CITY OF ALBUQUERQUE

August 31, 2017

**Re: Onate E. S. Classroom Building
12415 Brentwood Hills NE
Request 30-Day Temporary C.O. – Accepted
Engineer's Stamp dated: 11/19/2015 (H22D035)
Certification dated: 8-25-17**

File Path:	P:\QATA\2015\2015.007.1\ENG\AB\	Plot Date:	08-25-2017
File Name:	161847_CG-101_AB.DWG	Plot Time:	1:50 pm

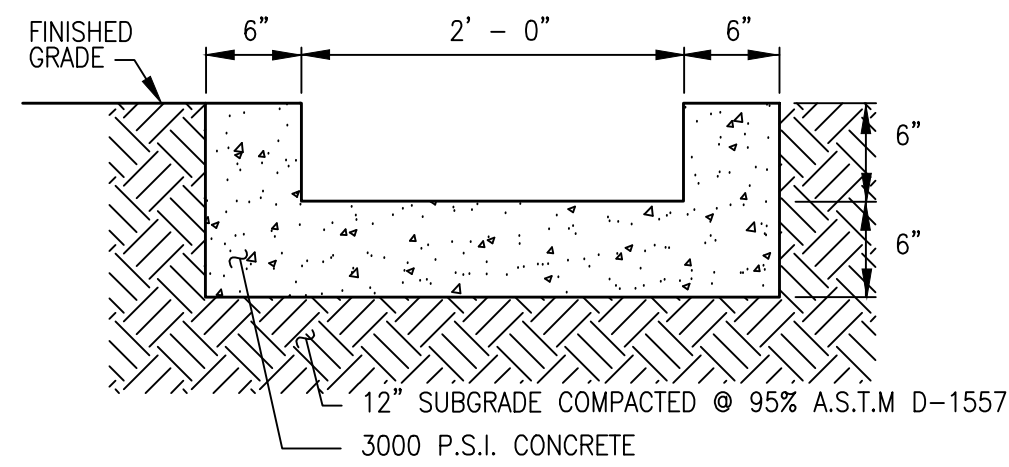
- Opening at grade in Mechanical Yard wall is missing
- 6" roof drain embedded in concrete rundown
- Water quality basin at SW corner not complete
- Inlet at SW corner does not appear to be constructed at flowline
